Subject: 21/00869/F - St Tropez East Street Bodicote OX15 4EB

Planning application: 21/00869/F
Location: St Tropez East Street Bodicote OX15 4EB
Description: Two storey front and rear extensions, with new pitched roofs replacing flat roof area to side of the property. Enlargement of vehicle access width in stone boundary wall (resubmission of 20/02280/F)
Type: Full Development
Case Officer: Emma Whitley

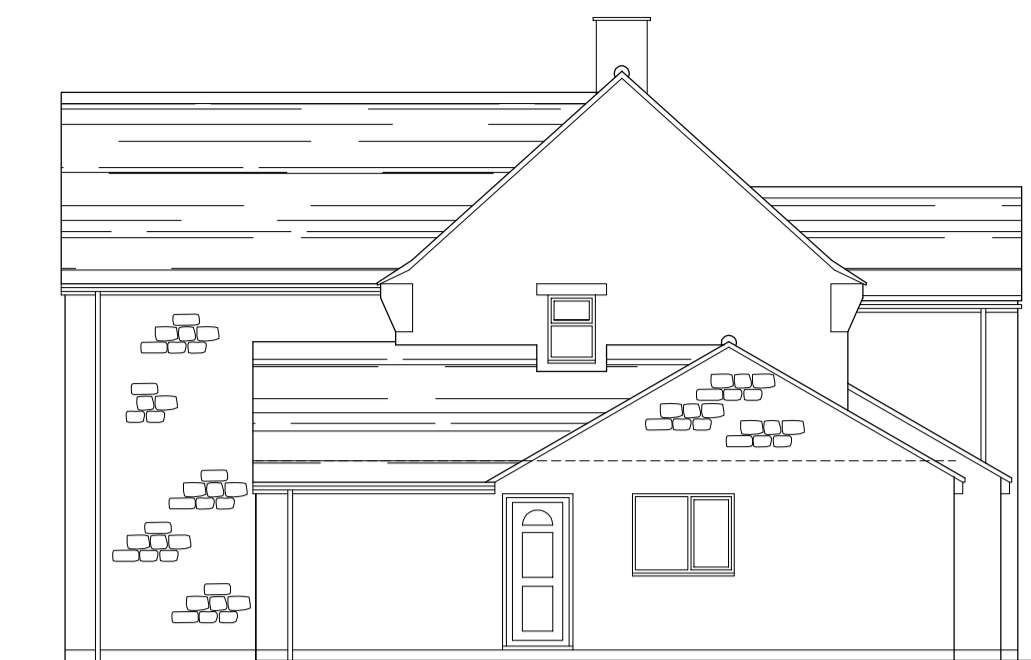
Prior to the first use/occupation of the development hereby approved, the parking and manoeuvring areas shall be provided in accordance with the plan approved Drawing No. 1933-05A and shall be constructed from porous materials or provision shall be made to direct run-off water from the hard surface to a permeable or porous area or surface within the curtilage of the site. Thereafter, the parking and manoeuvring areas shall be retained in accordance with this condition and shall be unobstructed except for the parking and manoeuvring of vehicles at all times. Reason - In the interests of highway safety and flood prevention and to comply with Policies ESD7 and ESD15 of the Cherwell Local Plan 2011-2031 Part 1 and Government guidance contained within the National Planning Policy Framework.

the applicant site. It is proposed to widen the existing vehicular access with the removal of a portion of the existing boundary wall.
